JMT Consulting
PO Box 199
Kingsford NSW 2032
0415 563 177
www.jmtconsulting.com.au

13 April 2026

This document provides responses to the traffic and transport related matters raised by the Department of Planning, Housing and Infrastructure (DPHI) and City of Sydney Council (Council) in their submissions to the site at 13-17 Oxford Street and 2 Verona Street, Paddington (SSD – 87245208).

Table 1: Responses to DPHI comments

Drawing Title
BASEMENT 3 PLAN

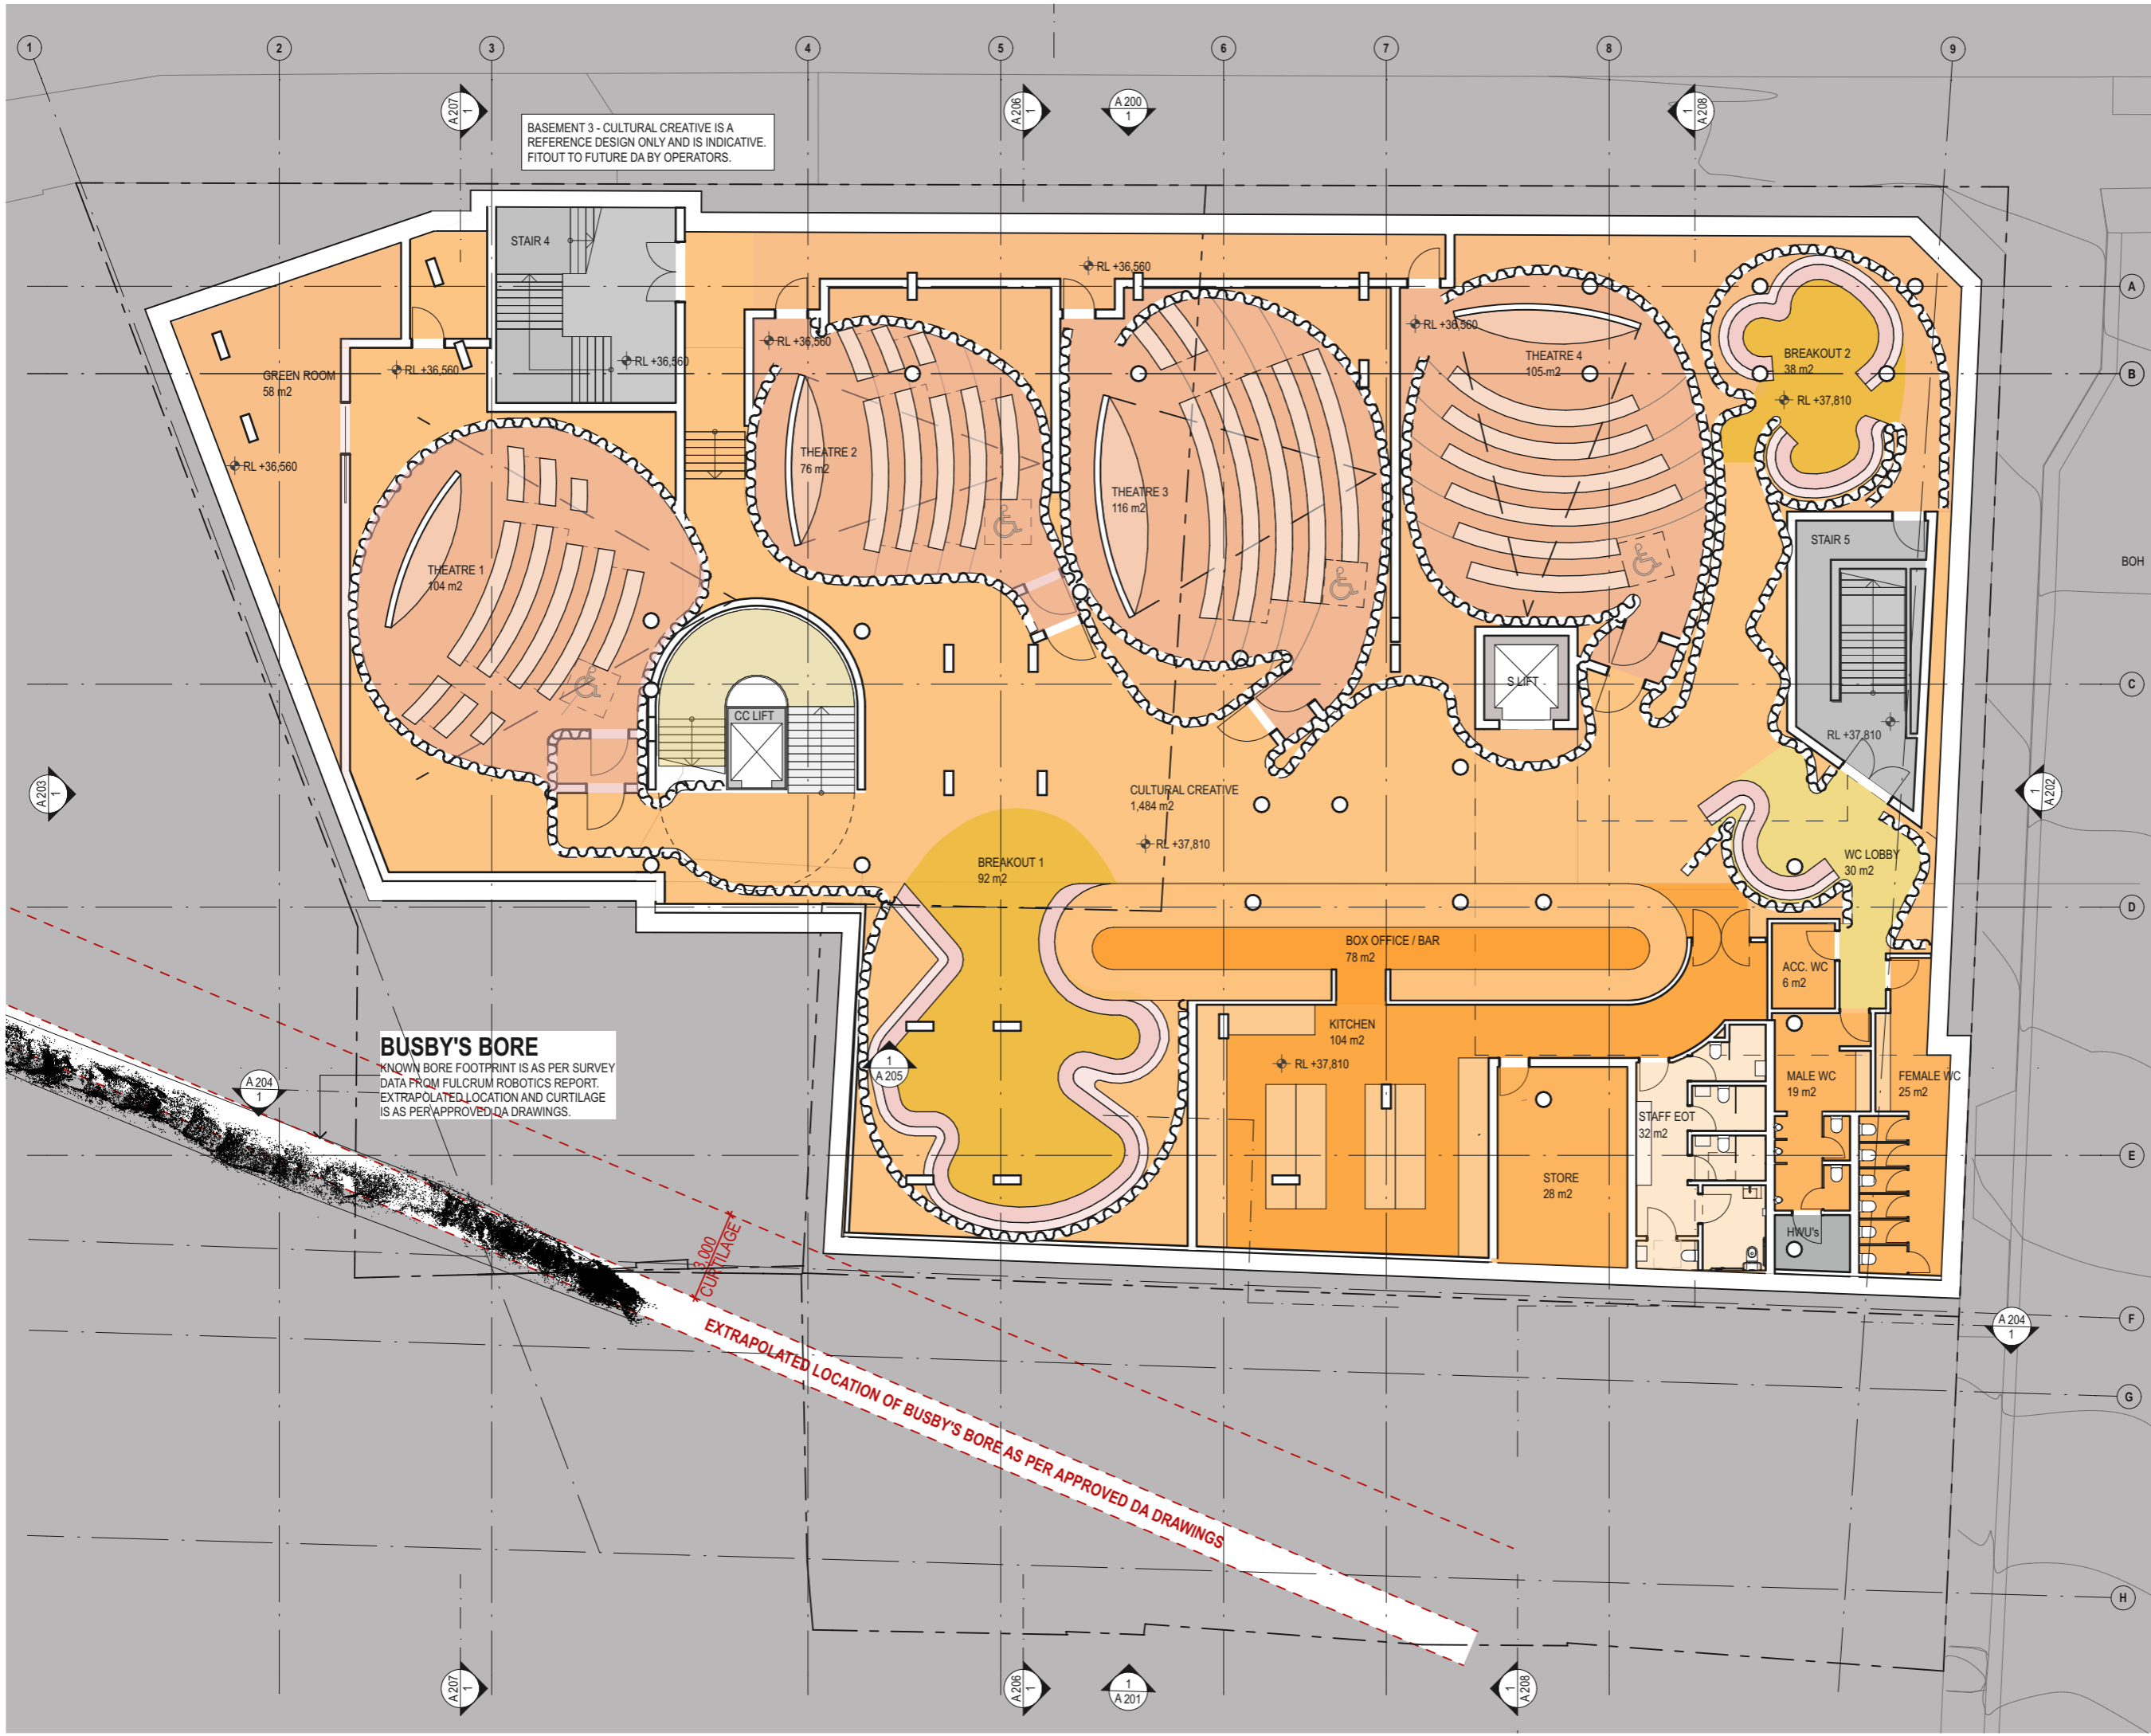
CoS Item Number	Council Comment	JMT Consulting Response
12.3	<i>Resident/ staff bicycle parking</i> The bicycle parking area on Basement 2 appears undersized to accommodate the proposed 62 bicycles. Bicycle parking manufacturers specifications should be provided to confirm compliance with AS2890.3, including height clearance if a dual height product is provided. End of Trip facilities for staff of the should also be provided within the development.	The bicycle parking numbers within the dedicated parking area on B2 have been calculated using the Cora Bike Rack product specifications as a reference, and is compliant with AS2890.3. The layout utilises the Cora ST-L dynamic upper tier, requiring a clear height of 2400mm and 700mm spacing between bicycles, in conjunction with alternating GP-F (front-in) and GP-B (back-in) lower tiers, allowing for 400mm separation between bicycles at that level. Each dashed grey box represents one bicycle at the lower tier, with the thicker lines representing one bicycle at the upper tier. Staff end of trip facilities are provided on Basement level 3 of the building.

Drawing Title
BASEMENT 1 PLAN

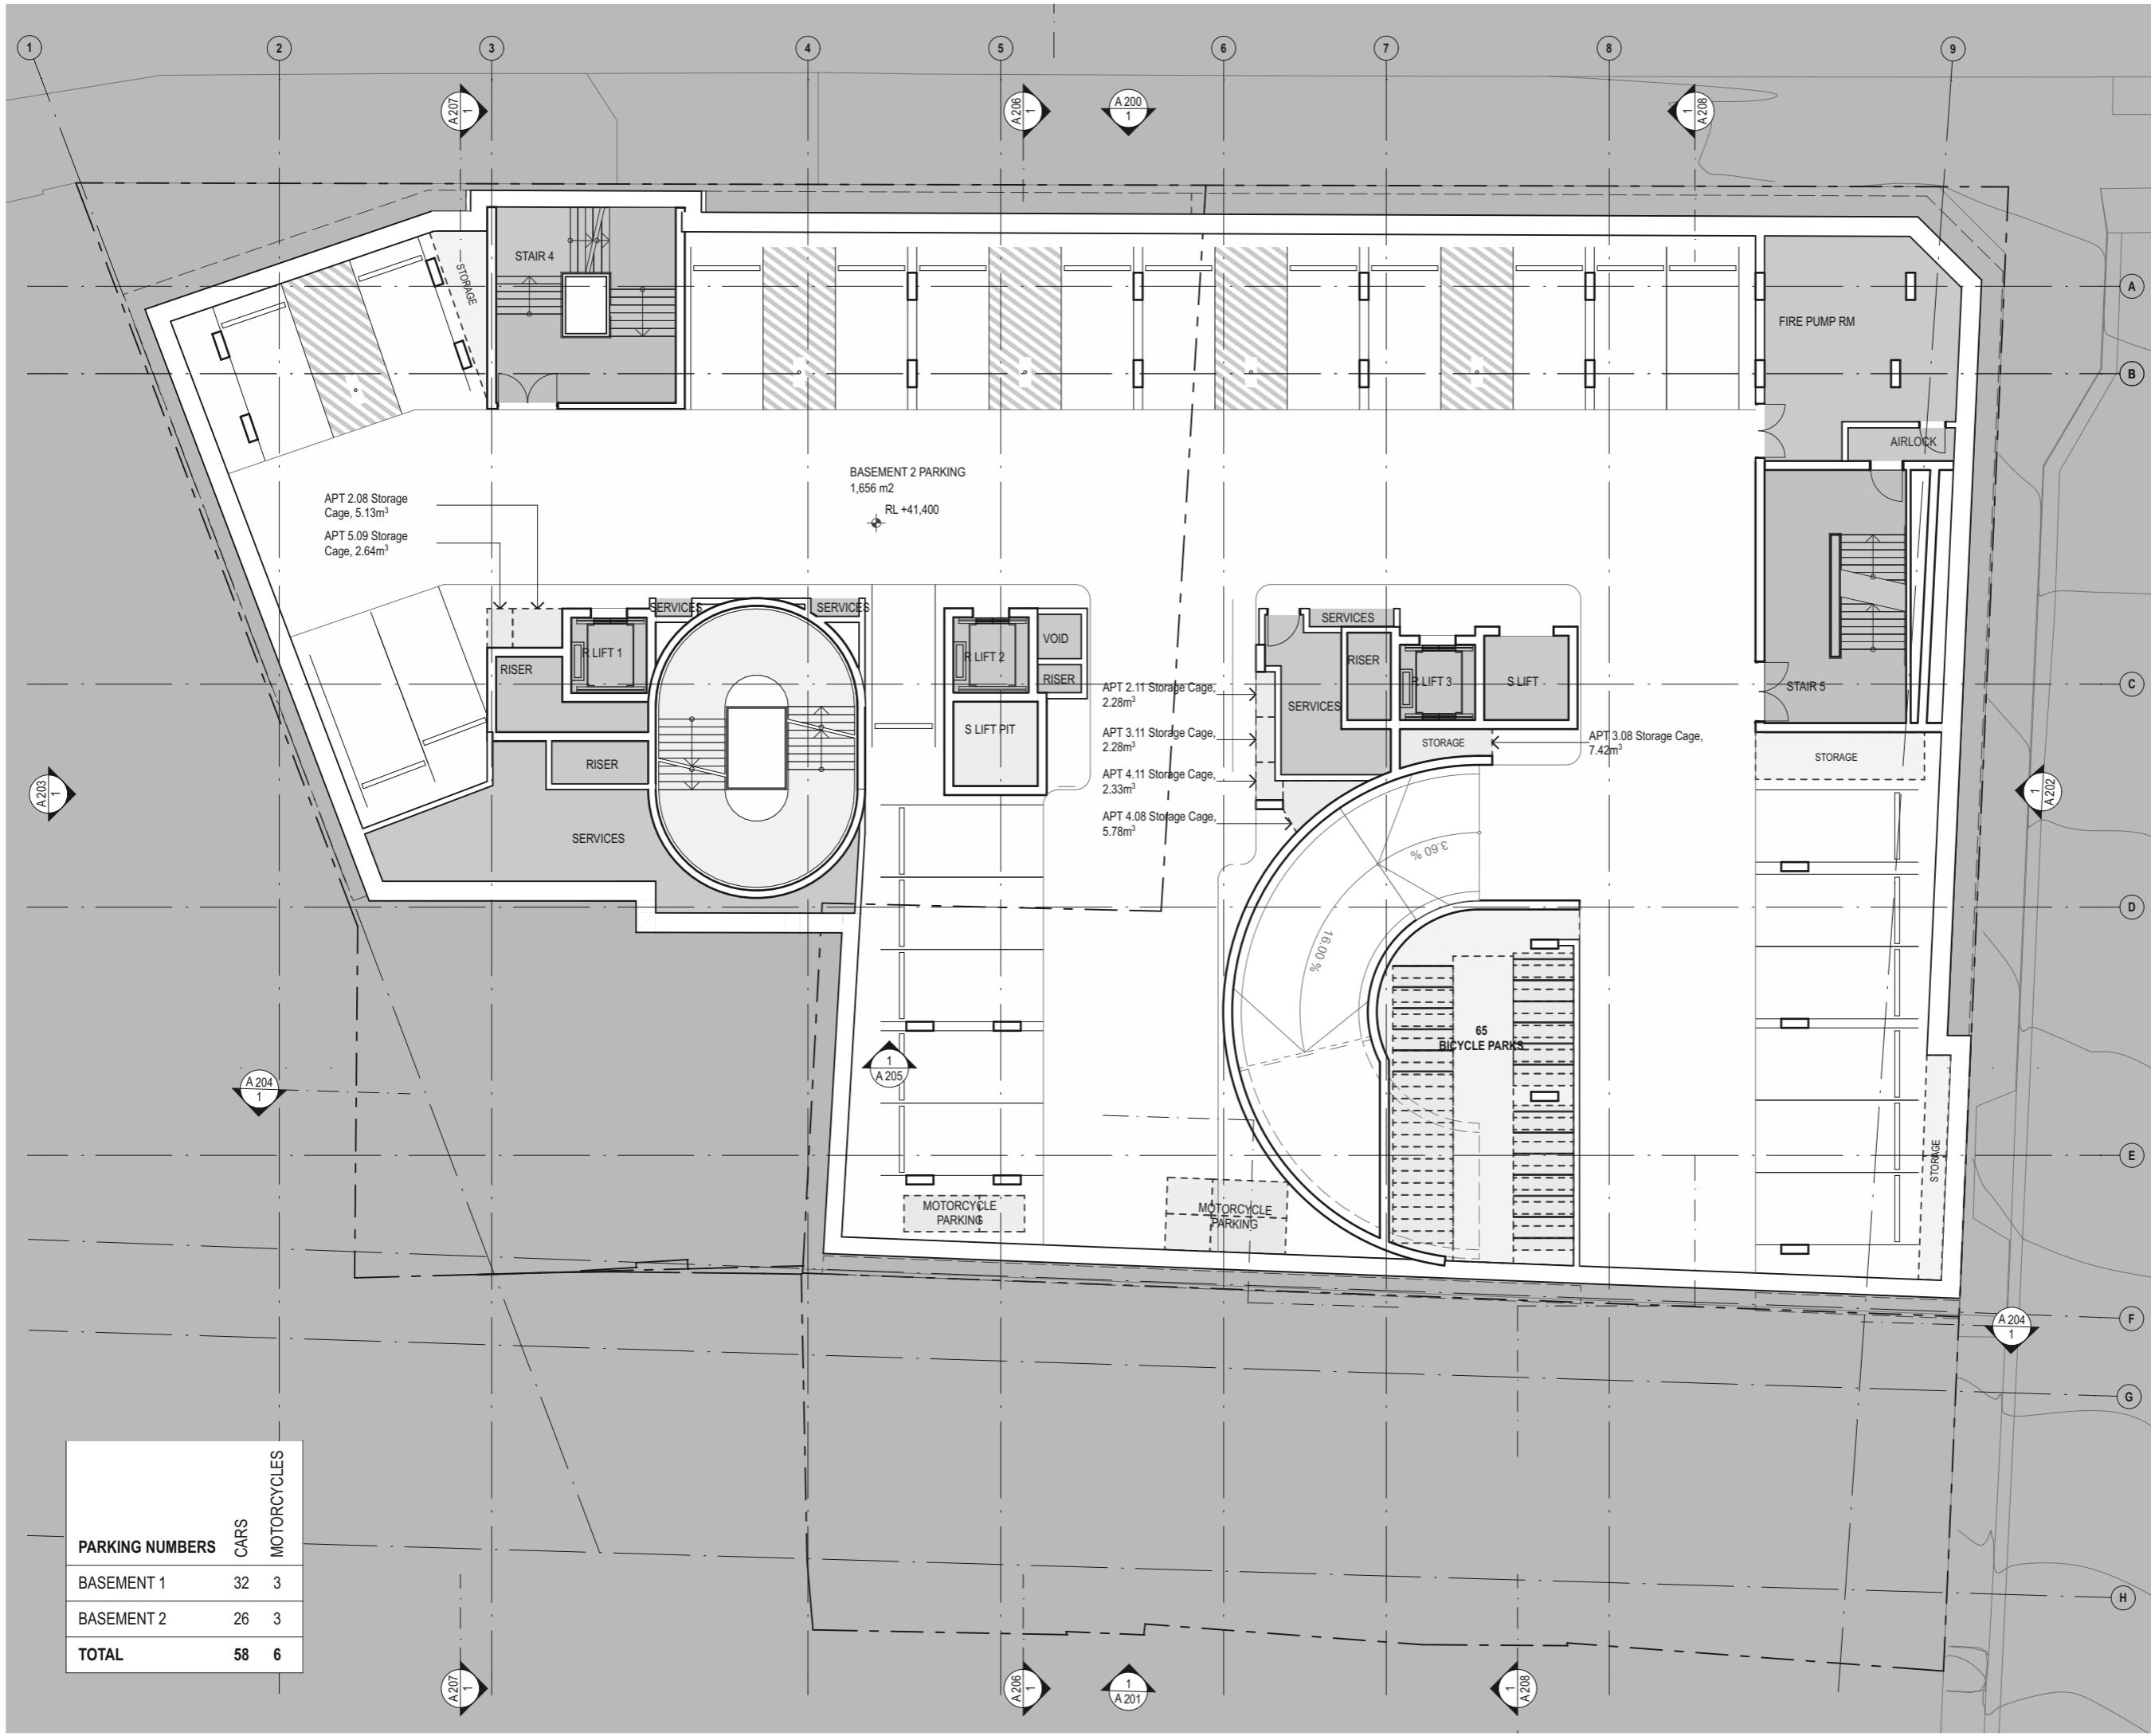
DPHI Item Number	DPHI Comment	JMT Consulting Response
23	Provide a breakdown of car parking allocation (including accessible parking) between market and affordable apartments.	The updated design provides for 58 parking spaces, allocated as follows: (i) Market apartments: - 48 regular parking spaces - 8 accessible parking spaces for the 8 adaptable units (ii) Affordable apartments - 2 accessible parking spaces for the 2 adaptable units
24	With regard to retail /cultural staff bicycle parking and access: (a) confirm how staff access to the basement bicycle parking spaces would be provided and managed. (b) confirm whether staff would have access to end -of -trip (EOT) facilities. If not, amend the proposal to provide EOT facilities , noting that these should form part of the proposal rather than part of a future tenancy fit -out development application given multiple tenancies are proposed.	(a) The bicycle parking on Level B2 can be accessed via either the main lobby area (arrival via Oxford Street) and then the passenger lift 3 down to basement level, or via the service lift through the loading dock. Staff and residents would be provided with swipe cards (or similar) to access the facility. (b) Confirming staff will be provided access to the end of trip facilities provided on basement Level 3. The EOT facilities will be provisioned as part of the base building inclusions.

CoS Item Number	Council Comment	JMT Consulting Response
12.2	<i>Vehicle access and car park design</i> The following amendments are required to the proposed vehicle access and car park design: i. The waiting bay is to be wholly located within the site's boundaries as cars are not permitted to queue across the footpath. ii. The proposed 8m wide driveway is to be reduced to a maximum of 6m in width to comply with the City's Technical Standards 2.6.8. iii. Confirmation of the access control method for the car park/ loading dock (location of roller shutter, intercoms etc.) is required. iv. Further details around how the single lane ramp signal system operates must be provided. Entry movements must be prioritised over exit movements and waiting bays should be shown for vehicles while the ramp is in use. v. Compliance with AS2890 series is required. Currently there is a column located in the accessible shared bay in Basement 1 and the bicycle parking area in Basement 2 which should be reconsidered. vi. It must be confirmed that the basement ramp gradients comply with AS2890.1 based on the gradients measured along the inner radius of the ramp. vii. The additional 6.5m by 2.8m loading bay is not sufficient to accommodate an MRV and should be updated as a courier bay on the plans.	i. The waiting bay is positioned wholly within the boundary as indicated in the updated architectural plans. ii. The driveway width has been minimised as far as practicable, however a wider width, compared to the generic 6m within the DCP, is required to accommodate the swept path of the 10.6m long Council waste truck as well as the on-site waiting bay. iii. A roller shutter is currently envisaged with residents to be provided with remote controls. This will be further developed during the detailed design phase of the project. iv. A waiting bay is provided at ground floor and a complementary traffic light system will be installed to managed vehicle movements on the single lane ramp. Cars will wait in the aisles of the basement should the ramp be in use by a vehicle travelling down ground level. v. Under AS2890.6 (2022) columns are permitted in shared bays in lieu of bollards. The design has been revised with accessible bays now located at basement 2. The bicycle parking area on Basement 2 has been designed in accordance AS2890.3 compliant product specifications – refer Appendix B. vi. All gradients comply with the relevant requirements under AS2890.1. This includes a 5% ramp section for 6m from the boundary for exiting vehicles so as to view any pedestrians walking along Verona Street. vii. The plans have been updated to note the additional loading space as a 'courier bay' as per Council's comments
